## *Rezoning Petition Review*

**Rezoning Petition #:** 20-74

**Location of Property:** Approximately 21.08 acres located along the south side of Harris Houston Rd, north of University City Blvd and east of I-485.

SHEET TITLE:
CONDITIONAL REZONING: CONCEPTUAL SITE PLAN
SHEET NUMBER:
RZ1.0

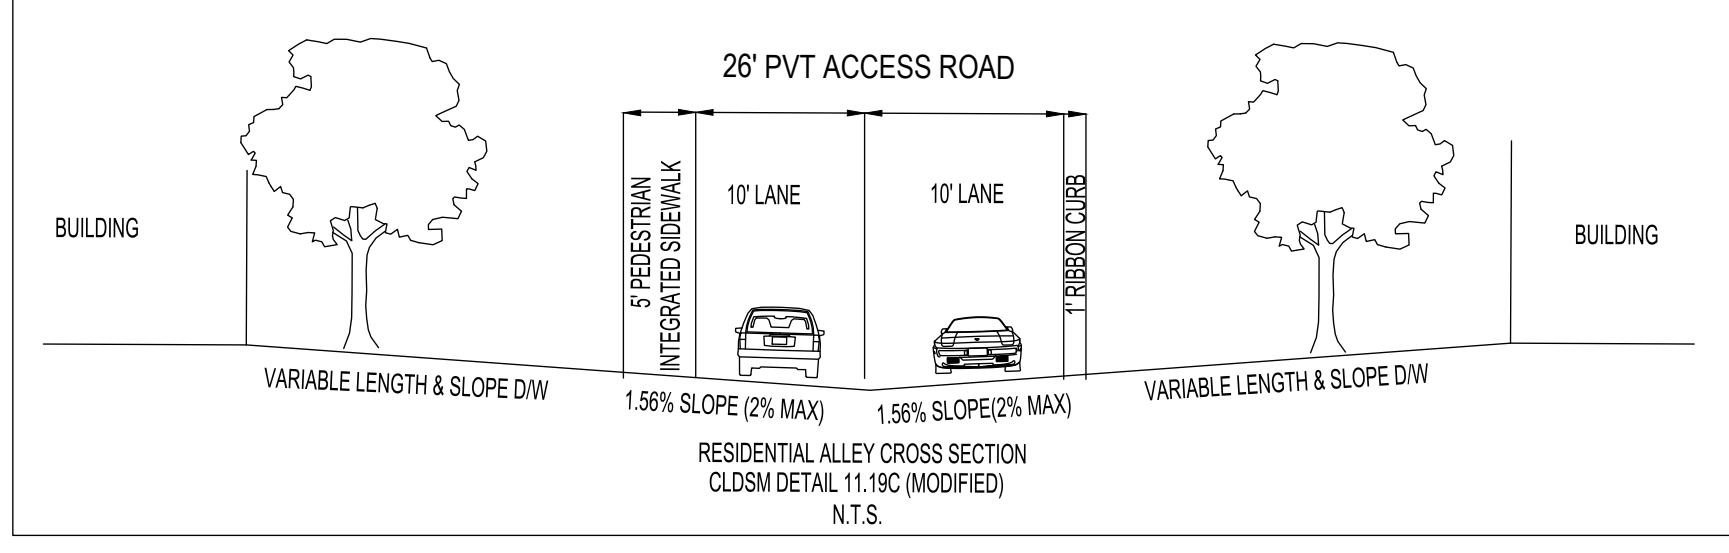
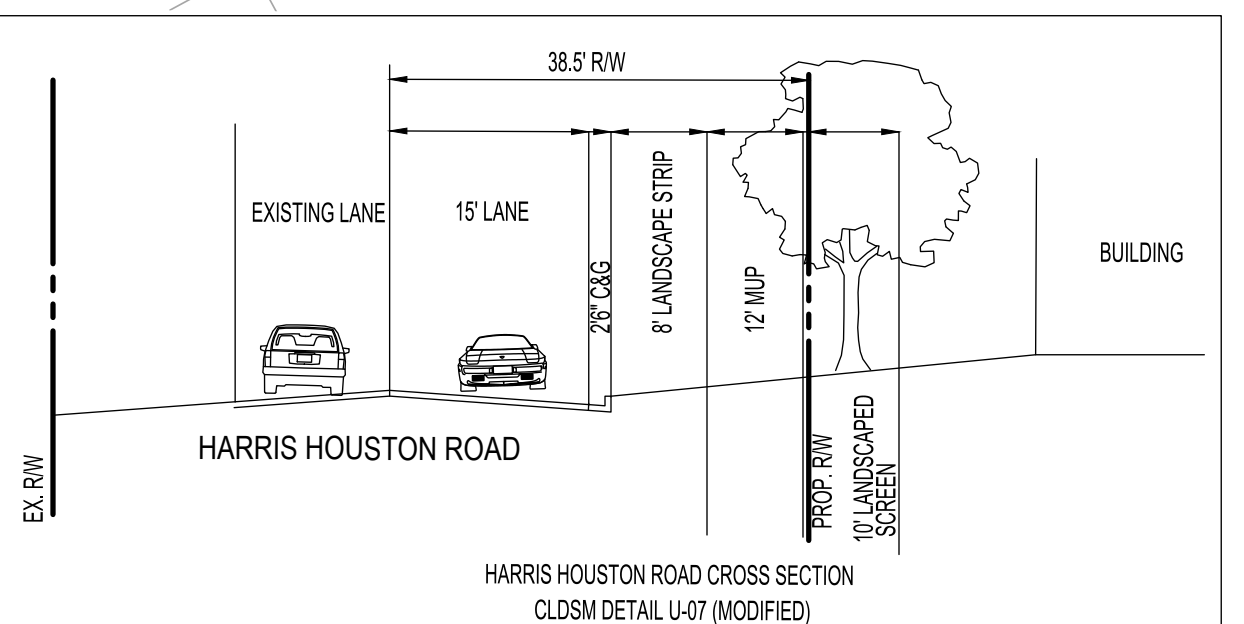
**Concerning Storm Water:** Plan sheet RZ-1 indicates a 100-ft Post Construction Stormwater Ordinance Buffer on site. Please revise buffer label to read “100-ft Undisturbed PCSO Buffer.”

The rezoning plan proposes several encroachments into SWIM and/or Post Construction Stormwater Ordinance stream buffers. Any increase of impervious area within such buffers may not be allowed and is not approved with the rezoning process. Please include the following note under Environmental Features: “*Development within the SWIM/PCSO Buffer shall be coordinated with and subject to approval by Charlotte-Mecklenburg Storm Water Services and mitigated if required by City ordinance.*” Please note Stream Delineation Reports are subject to review and approval by Charlotte Storm Water Services.
